Connah's Quay Low Carbon Power

Applicant's Response to Deadline 2 Submissions

Planning Inspectorate Reference: EN010166

Document Reference: EN010166/APP/9.14

PROJECT

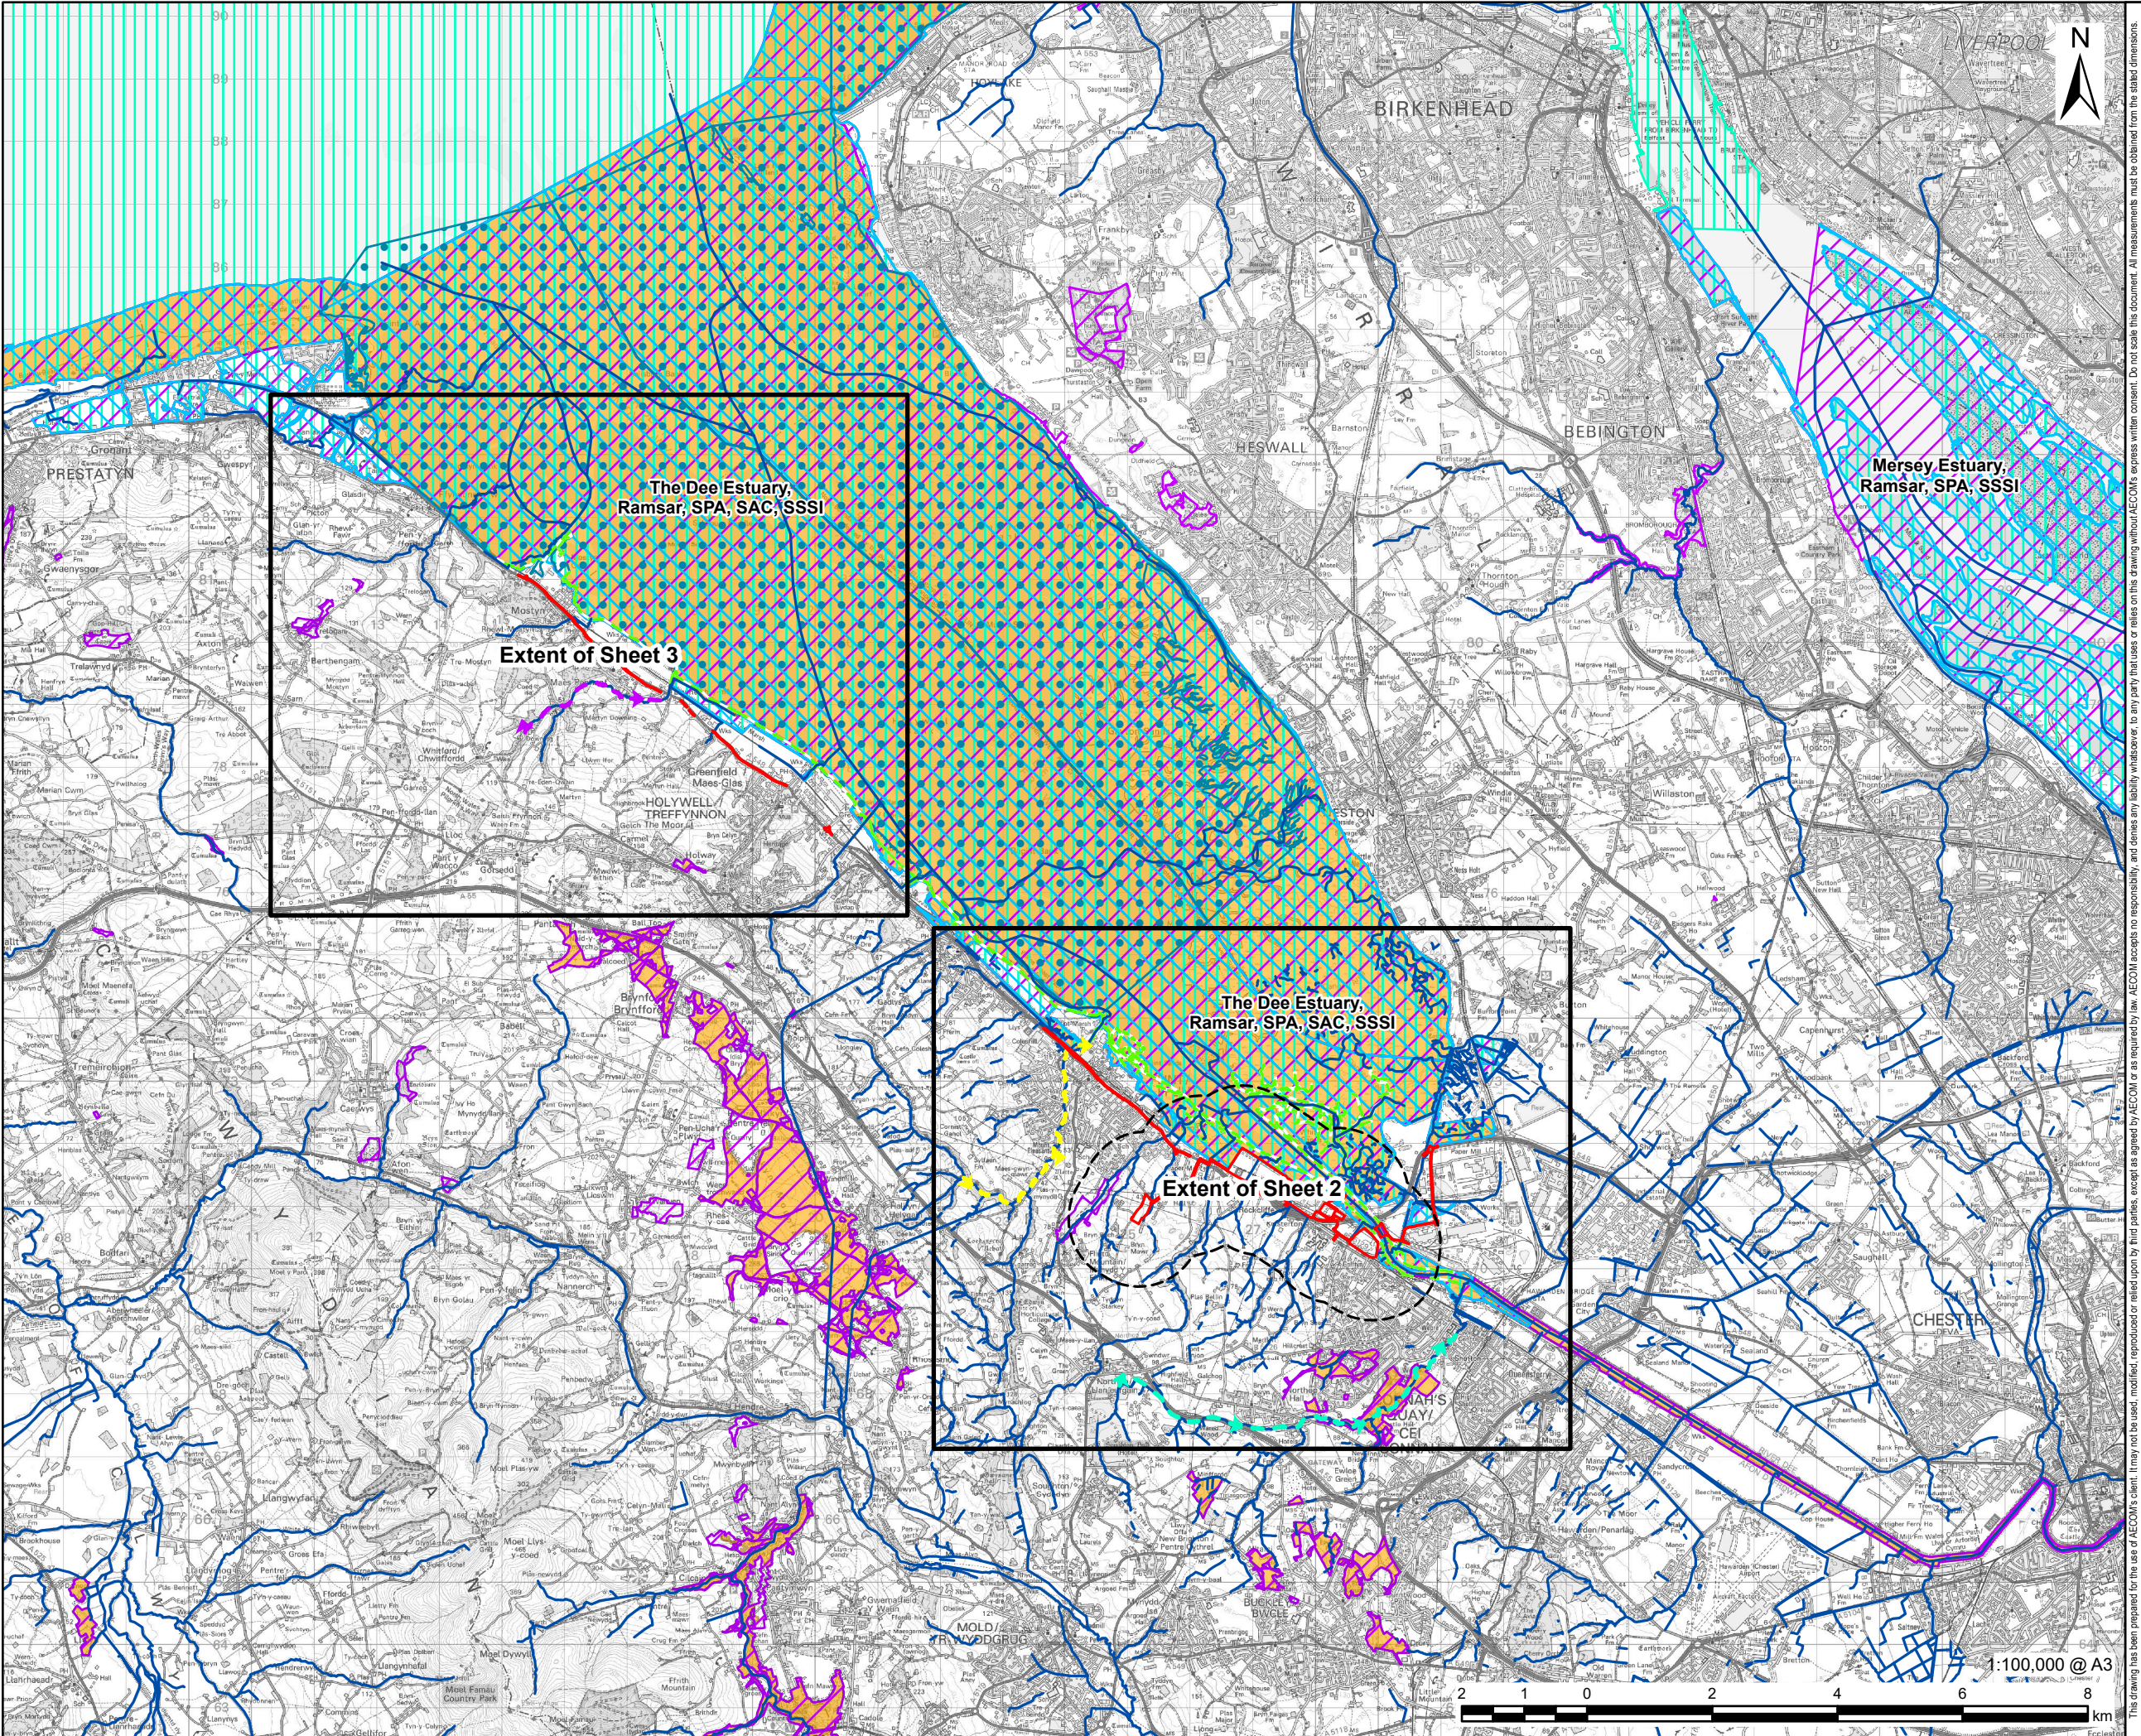
| Source Document | Reference | Source Document Issue / Theme | Applicant's Response |
|-----------------|-----------|--|--|
| | 1.11 | <p>Figure 13-1: Surface Water Features, by AECOM, dated January 2026 [REP1-015]</p> <p>We note and welcome that Figure 13-1 has been updated to include the screened-out Water Framework Directive water bodies, namely Wepre Brook and Nant Sir Roger (Dee Estuary). We therefore have no further concerns regarding this matter</p> | This is noted and welcomed by the Applicant. |
